GRANDVIEW RESERVE PHASE 2 PUD DEVELOPMENT PLAN & PRELIMINARY PLAN

GRANDVIEW RESERVE - PHASE 2
D.R. HORTON
EL PASO COUNTY, CO

COVER & TYP. SECTIONS
TYPICAL SECTIONS

SHEET
 ADJ 03

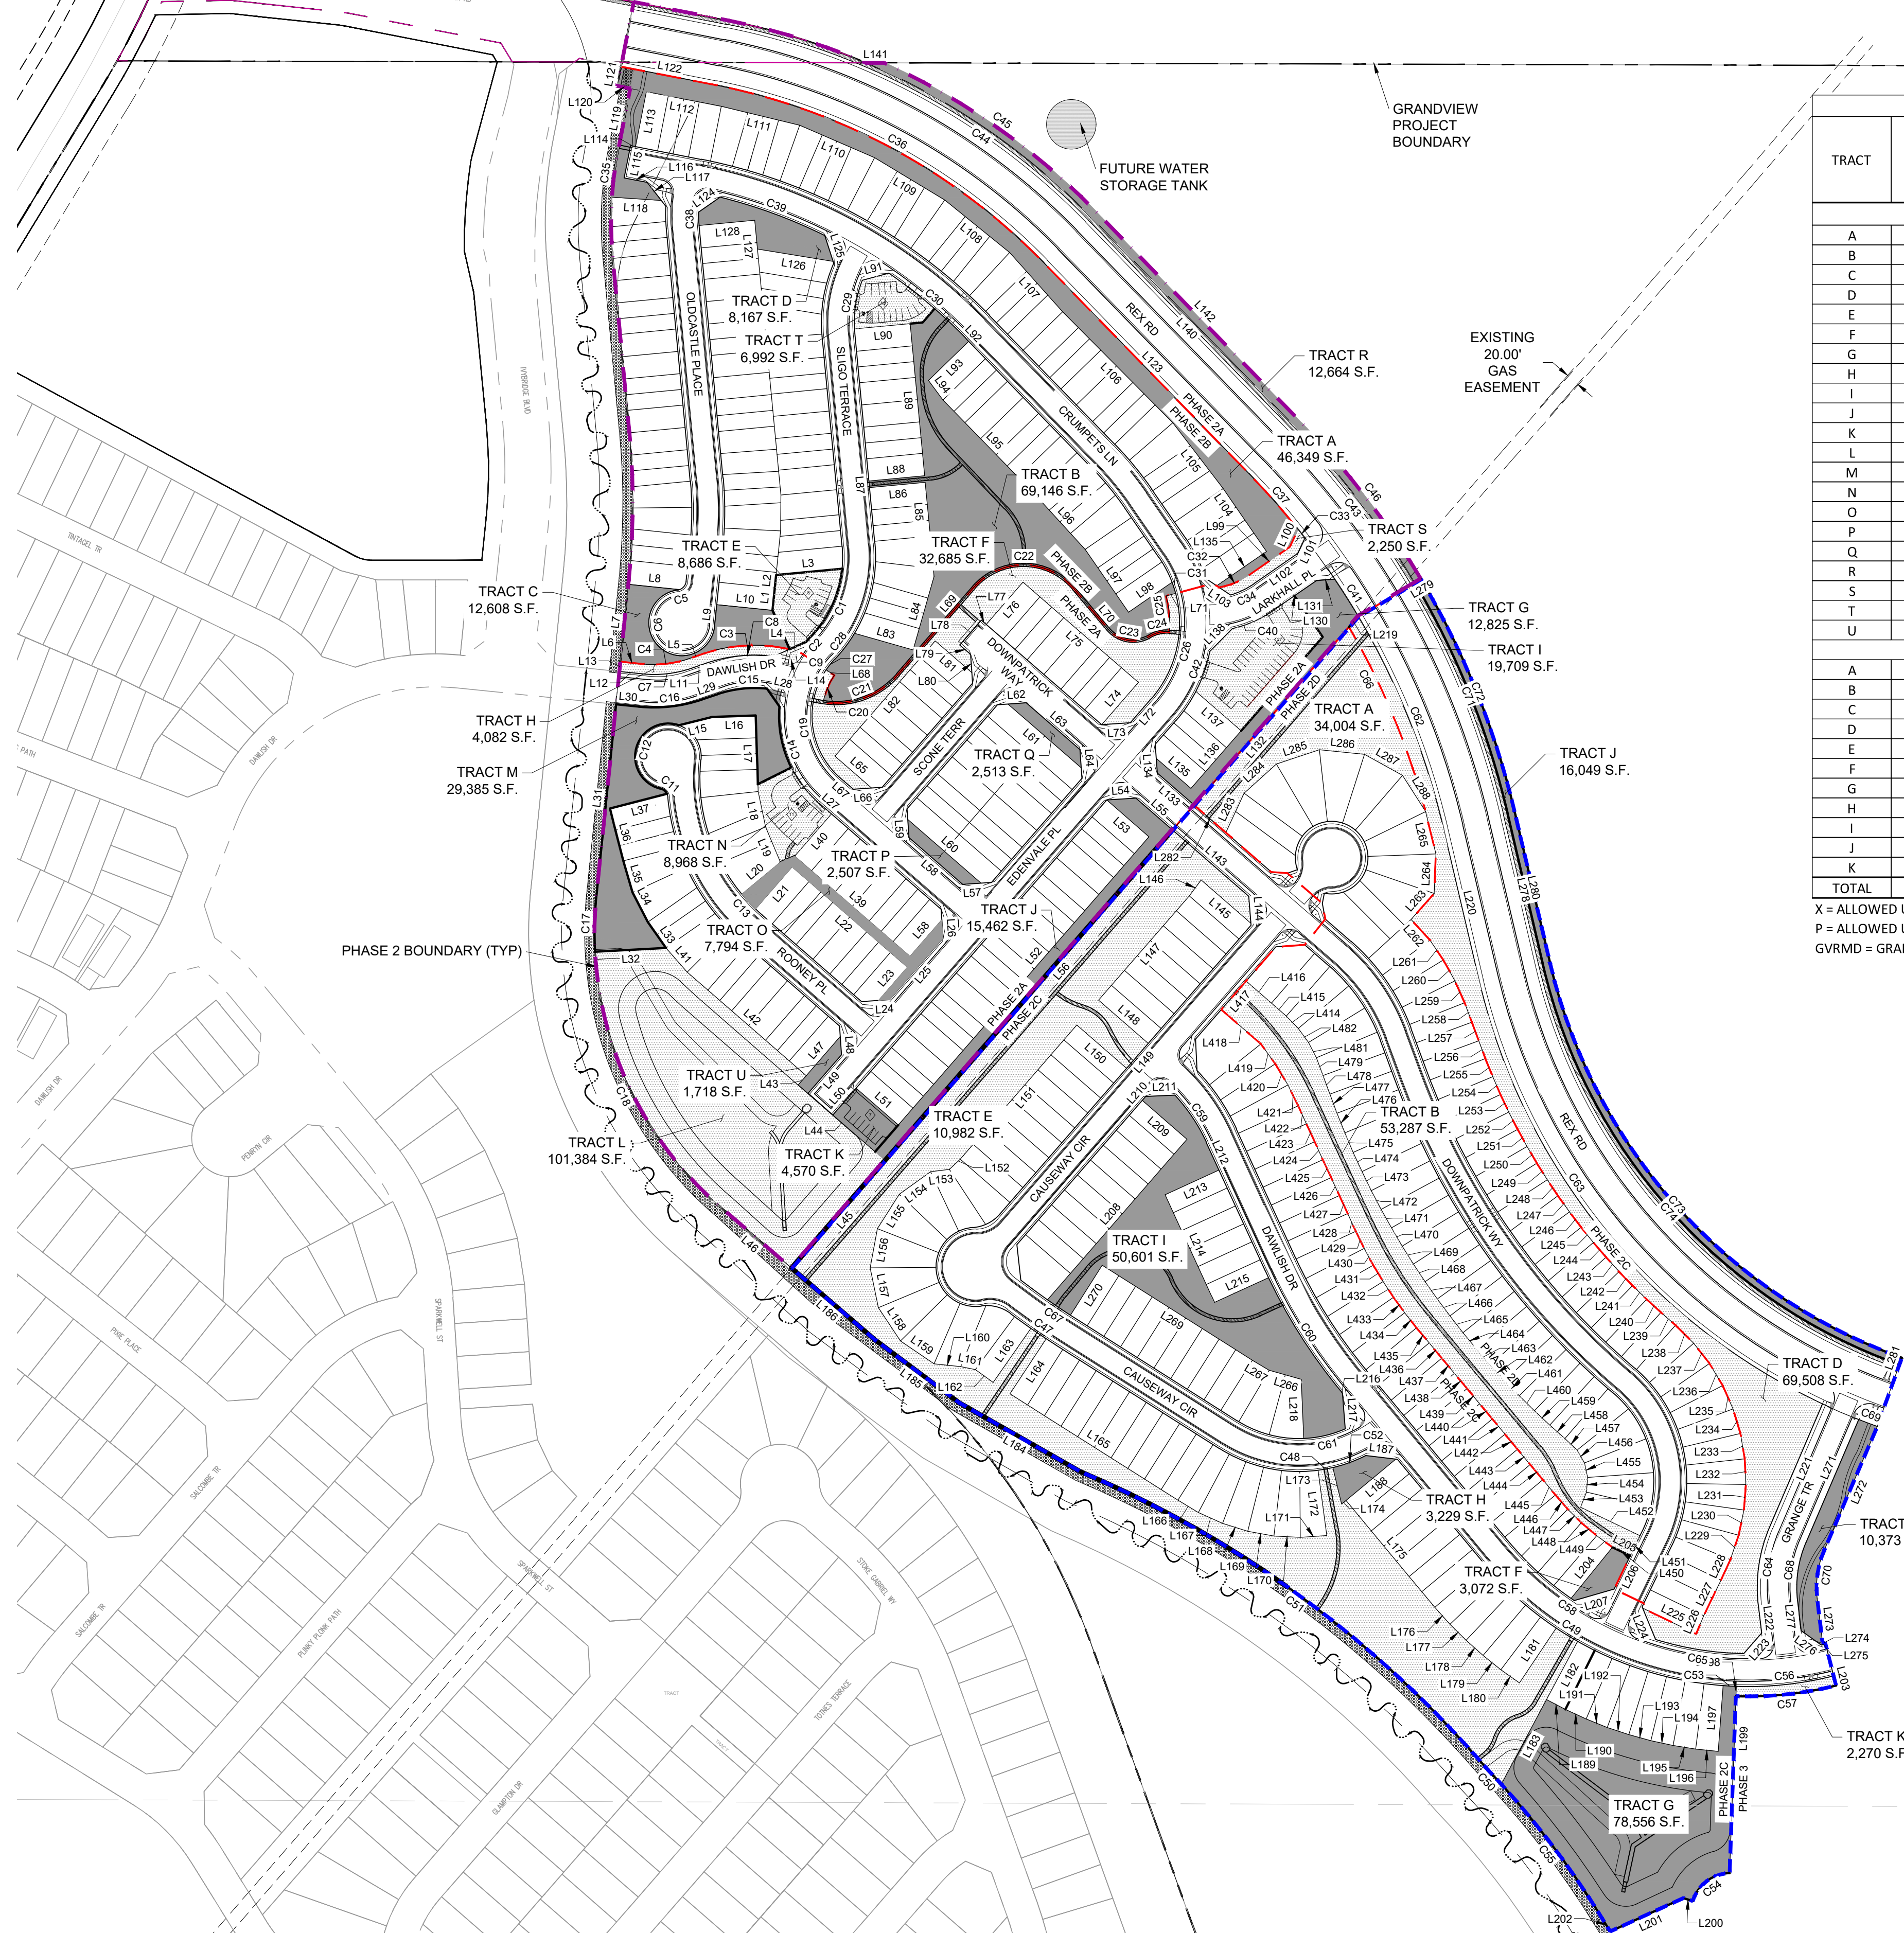
not needed beyond red line here- maybe add the mapped geo constraints and hazards here and zoom in

none of the geotechnical constraints and hazards are identified... sample below

Add a line to distinguish areas that are single family attached Townhomes attached verses the single family attached duplex

pu is recorded in black and white on mylar so this is not going to be legible.; use a hatch w labels for the first phase and then a hatch for the 2cd phase- no need to break into filings

SHEET TP 04

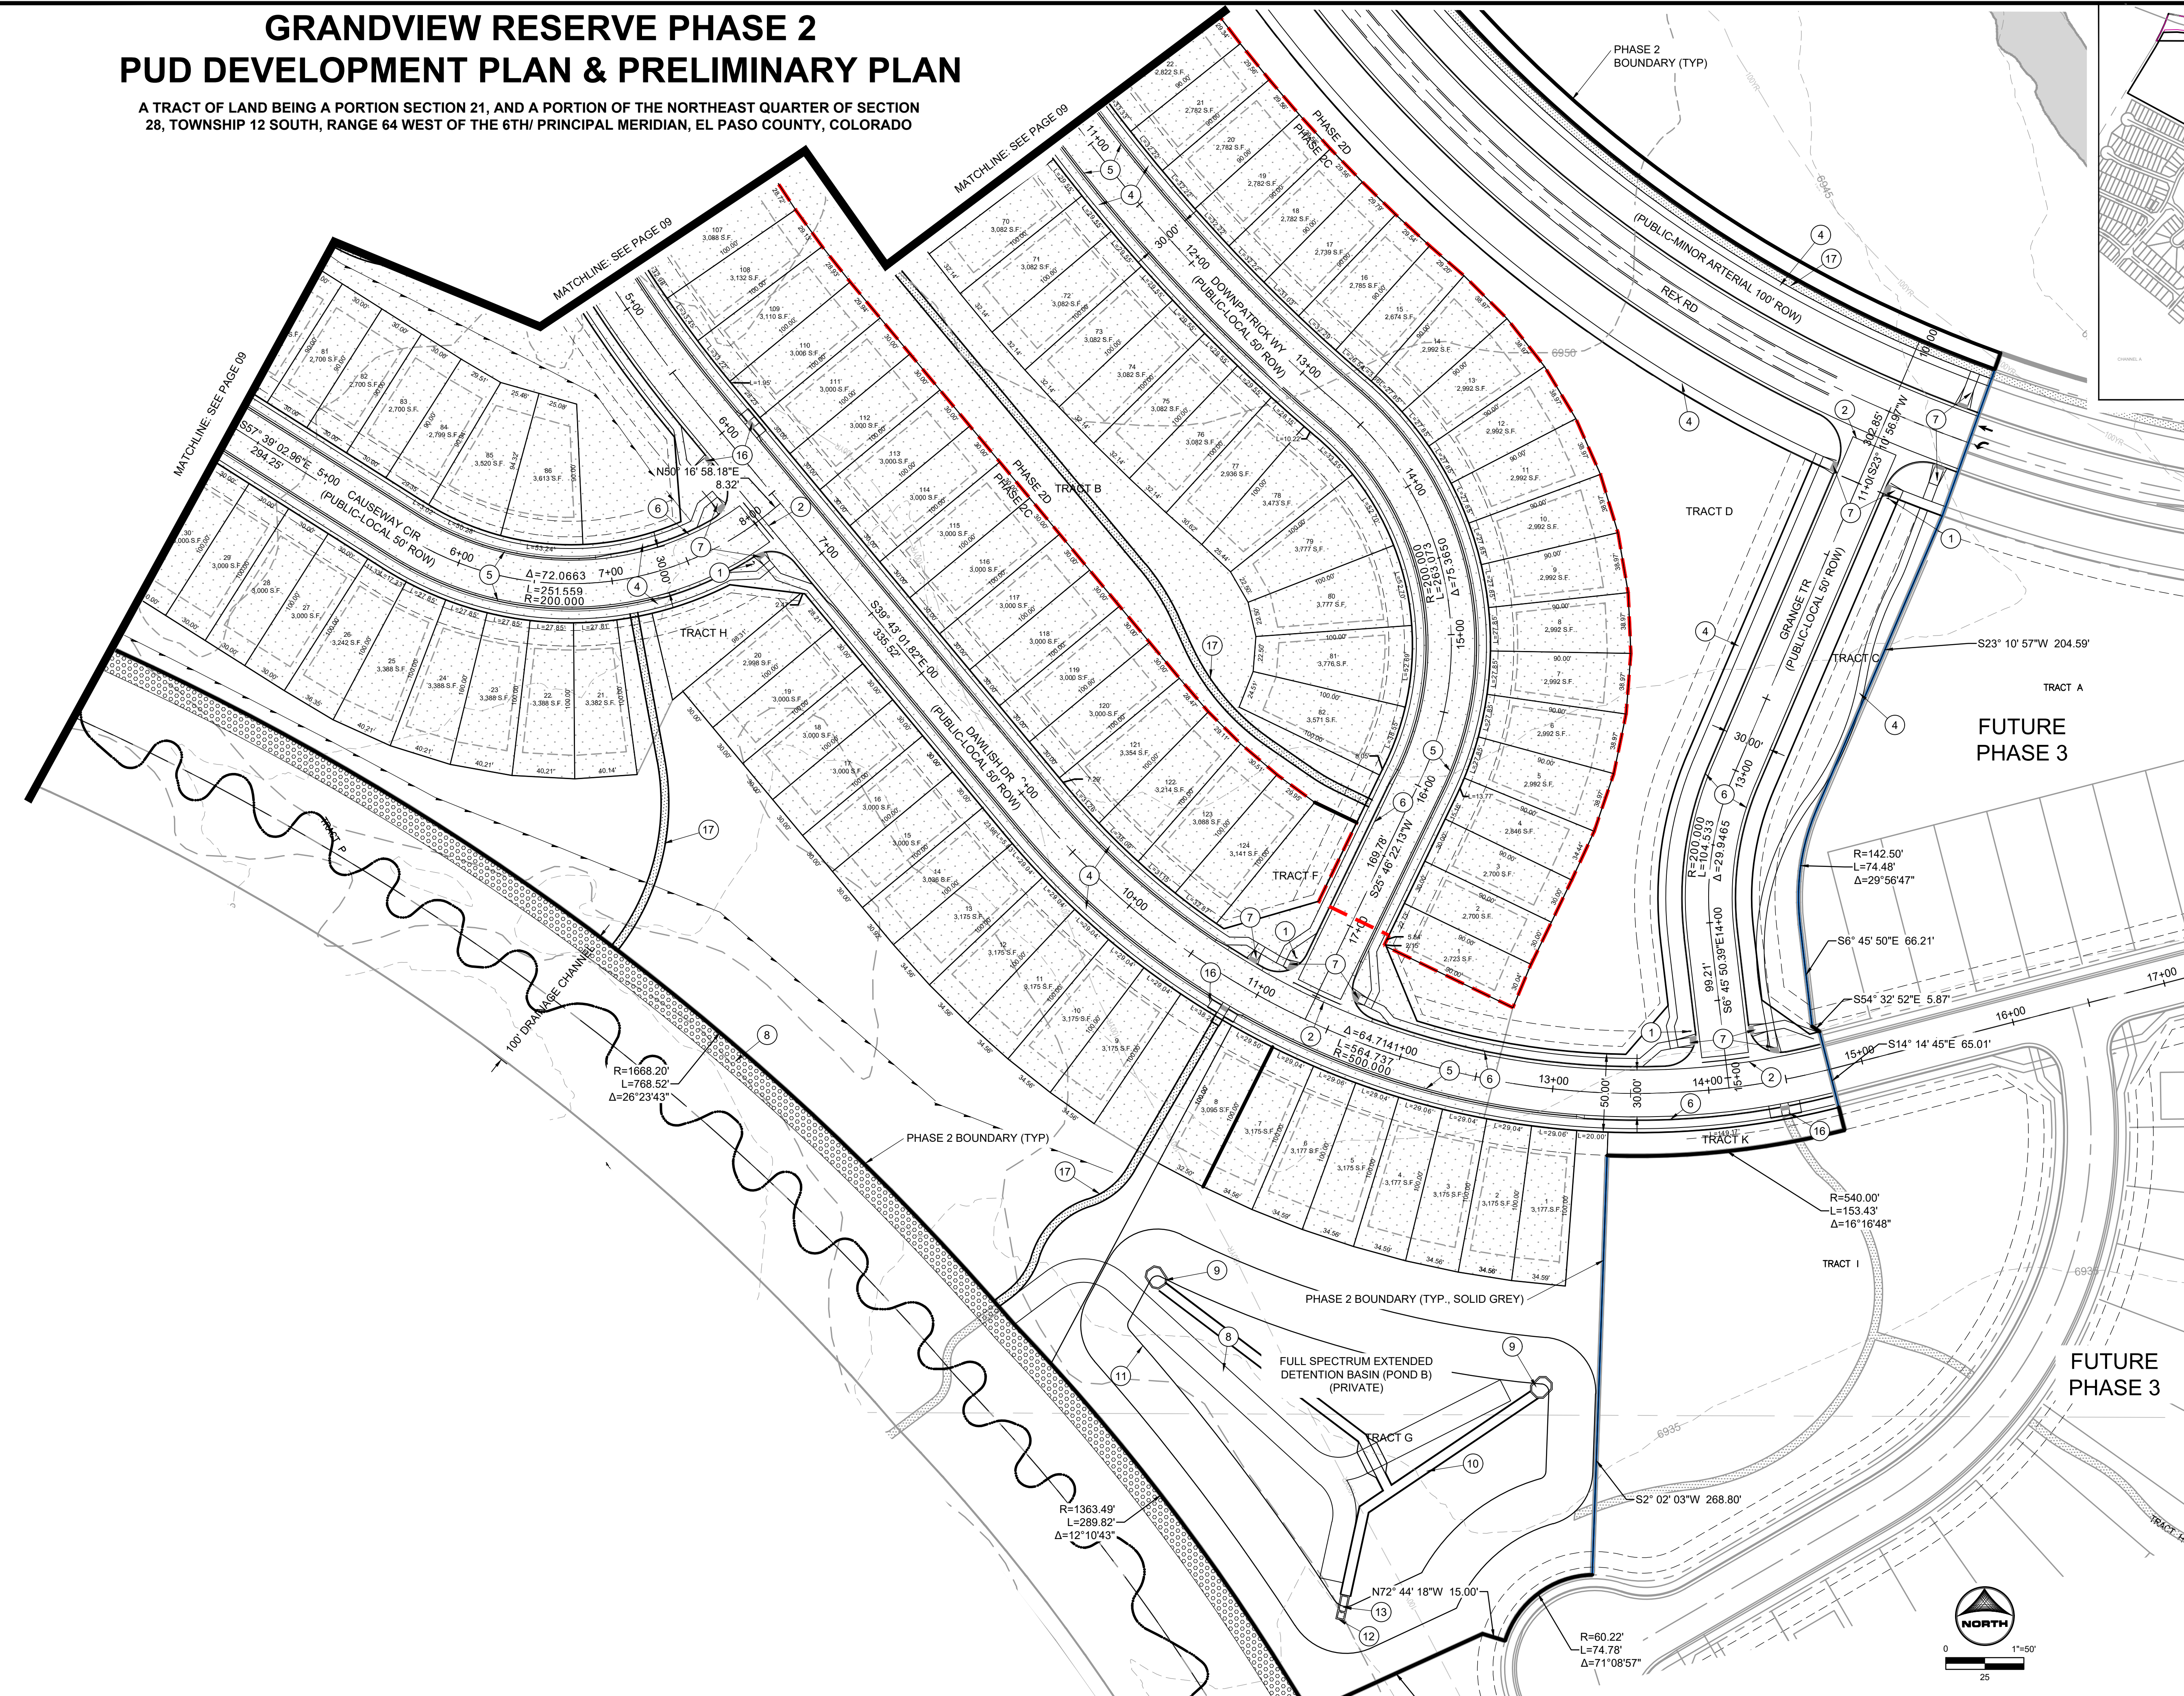
which area is single-family duplex and single family townhome?

this is not openspace nor park if there are structures roads etc

SHEET TYP 02

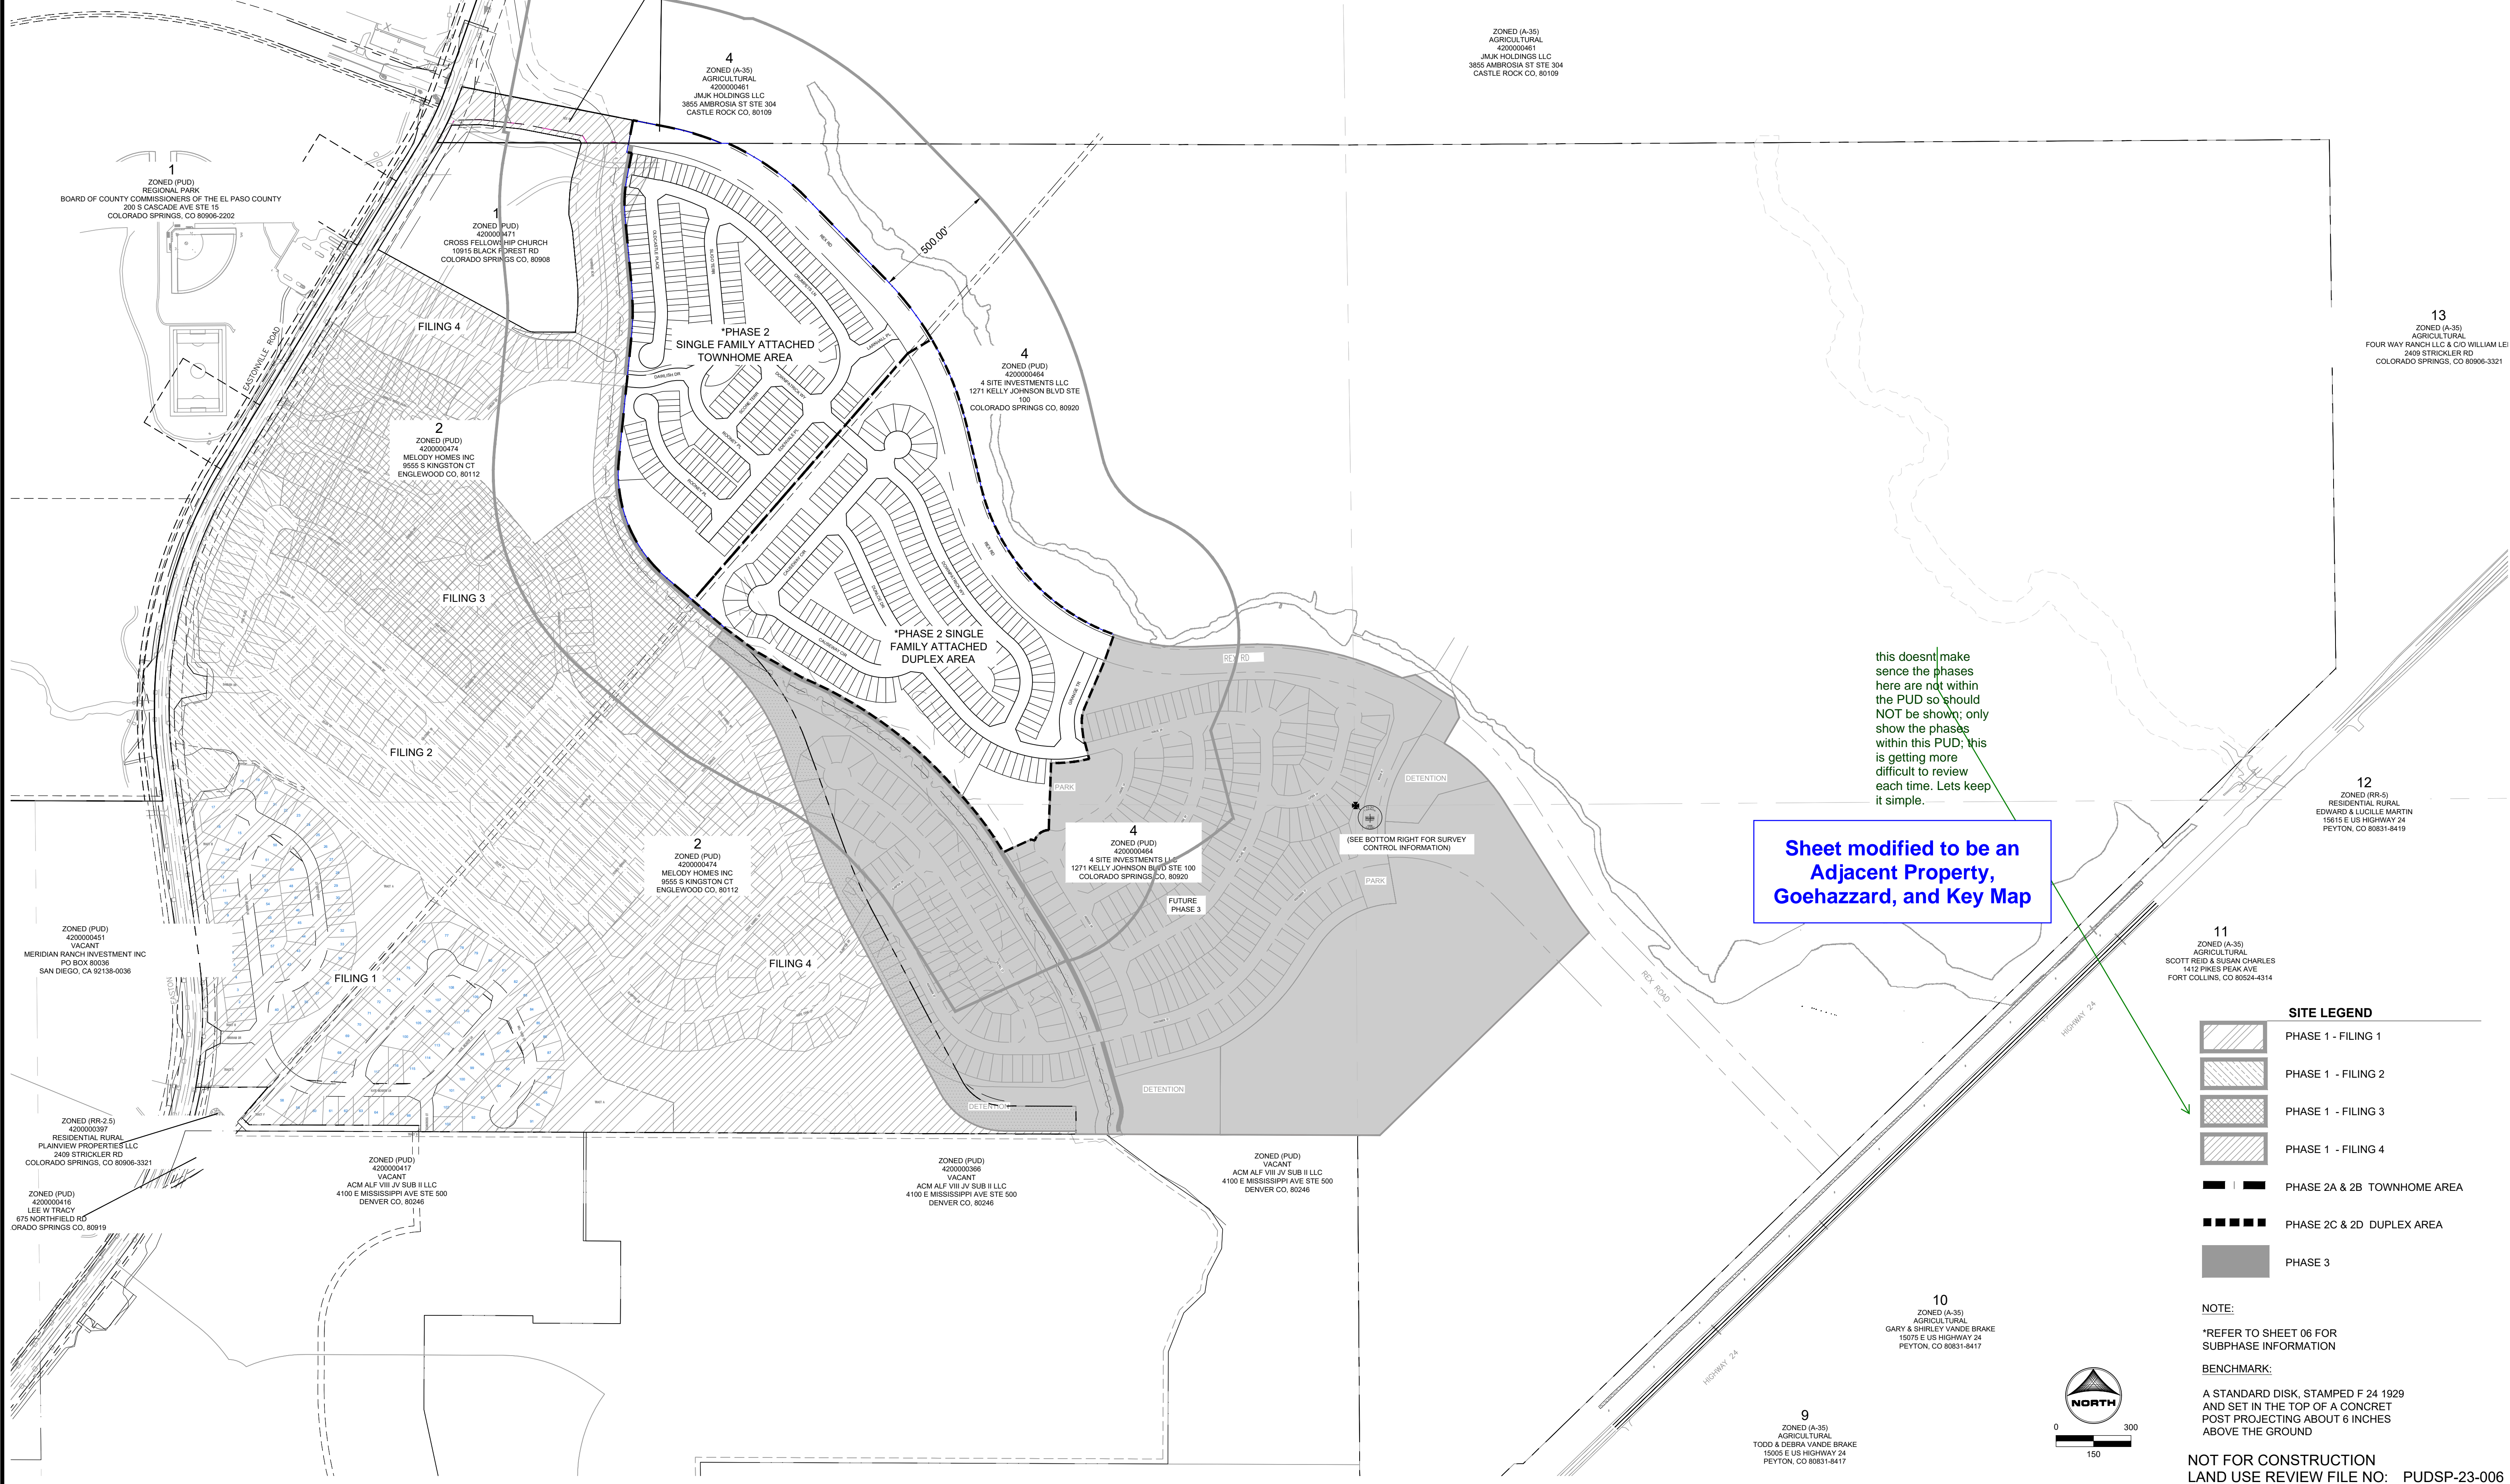
Does not meet EPC Standard Detail for arterial. Has a deviation been requested for this road? See additional information for this comment in TIS.

ADDRESSED
add road names to these so we know what cross section is for which road

Deviation will need to be provided for this section as it does not meet EPC Standards.

HRG RESPONSE: This section was proposed as part of the Phase 1 PUD/PP, we have researched the file and determined that a Deviation had not been approved at that time. We are requesting a Deviation as part of the Phase 2 Submittal

HRG RESPONSE: A Deviation is now being requested with this resubmittal.
